**From:** Anthony.Collier@hertfordshire.gov.uk  
**Sent:** 28 June 2017 15:37  
**To:** Planning  
**Subject:** Planning application 6/2017/1176/PN11 - Blackhorse House, 36 Salisbury Square

**District ref:** 6/2017/1176/PN11

Blackhorse House, 36 Salisbury Square  
Hatfield  
AL9 5DD

Prior approval for the change of use from Office (B1 (a)) to a Dwellinghouse (C3) to include the creation of 16x 1 bedroom flats

TITLE
PARKING PLAN

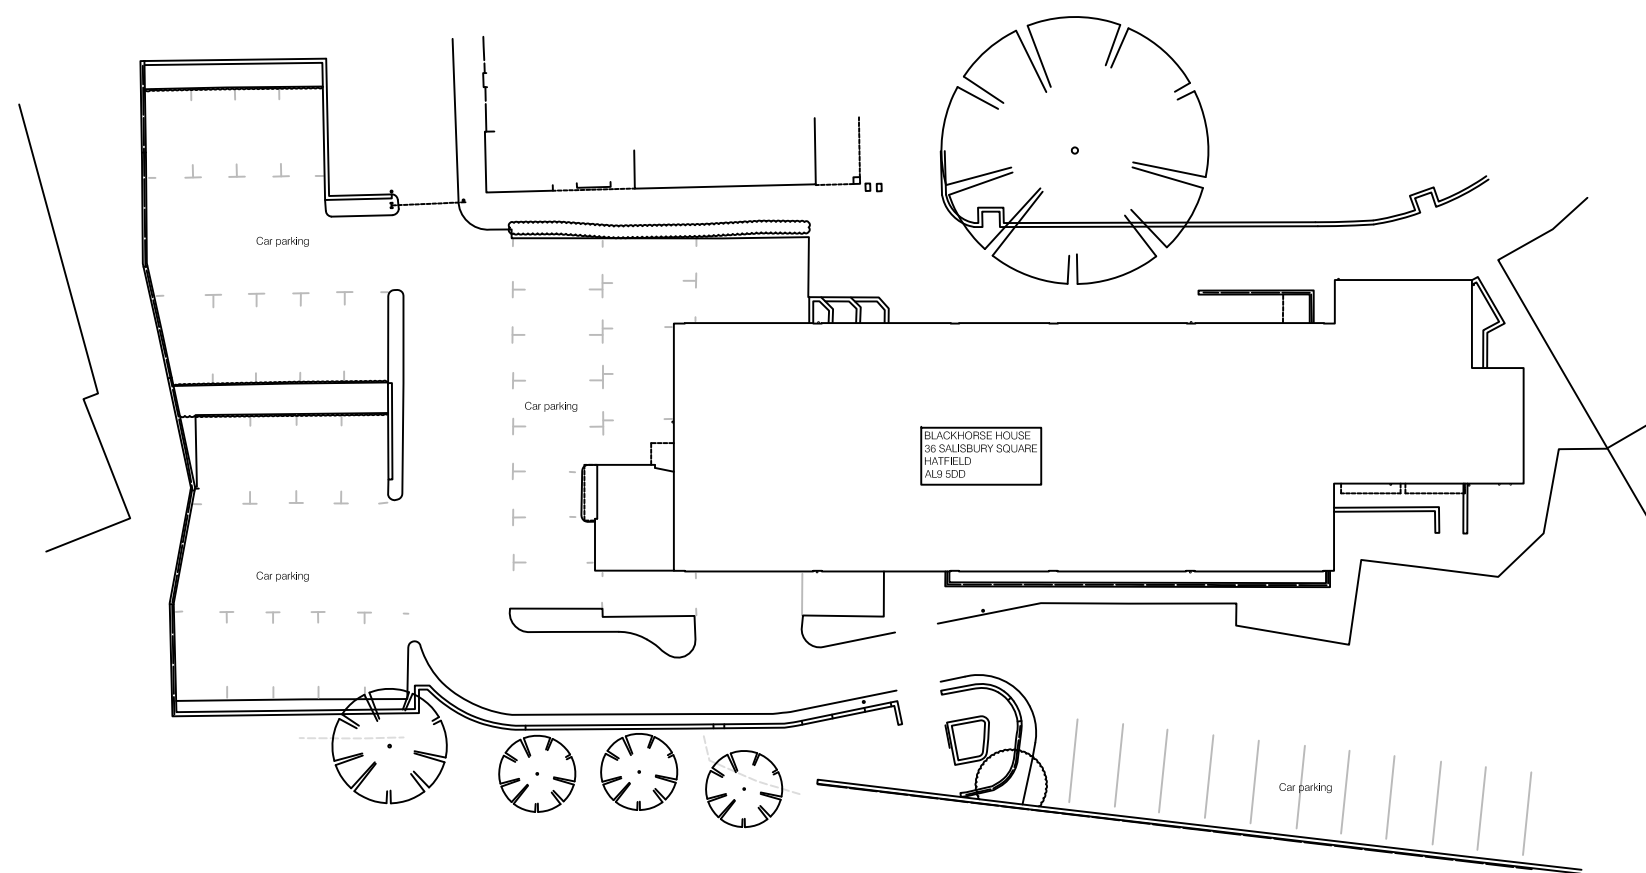
Accessibility arrangements appear to remain unchanged from the existing office use, with all parking provision laid out to acceptable and suitable dimensions. It is recommended that the LPA consult the relevant emergency services with regard to access arrangements.

With the change of use it is unlikely to result in an increase of trip generation compared to that achievable in the existing use class. Parking provision should be reviewed by the LPA, notably due to the mix of residential dwellings locally and parking restrictions in the area.

It is unclear if bicycle parking is provided, but would be achievable and recommended. Access to other sustainable forms of transport is directly adjacent to the site at Hatfield Station.
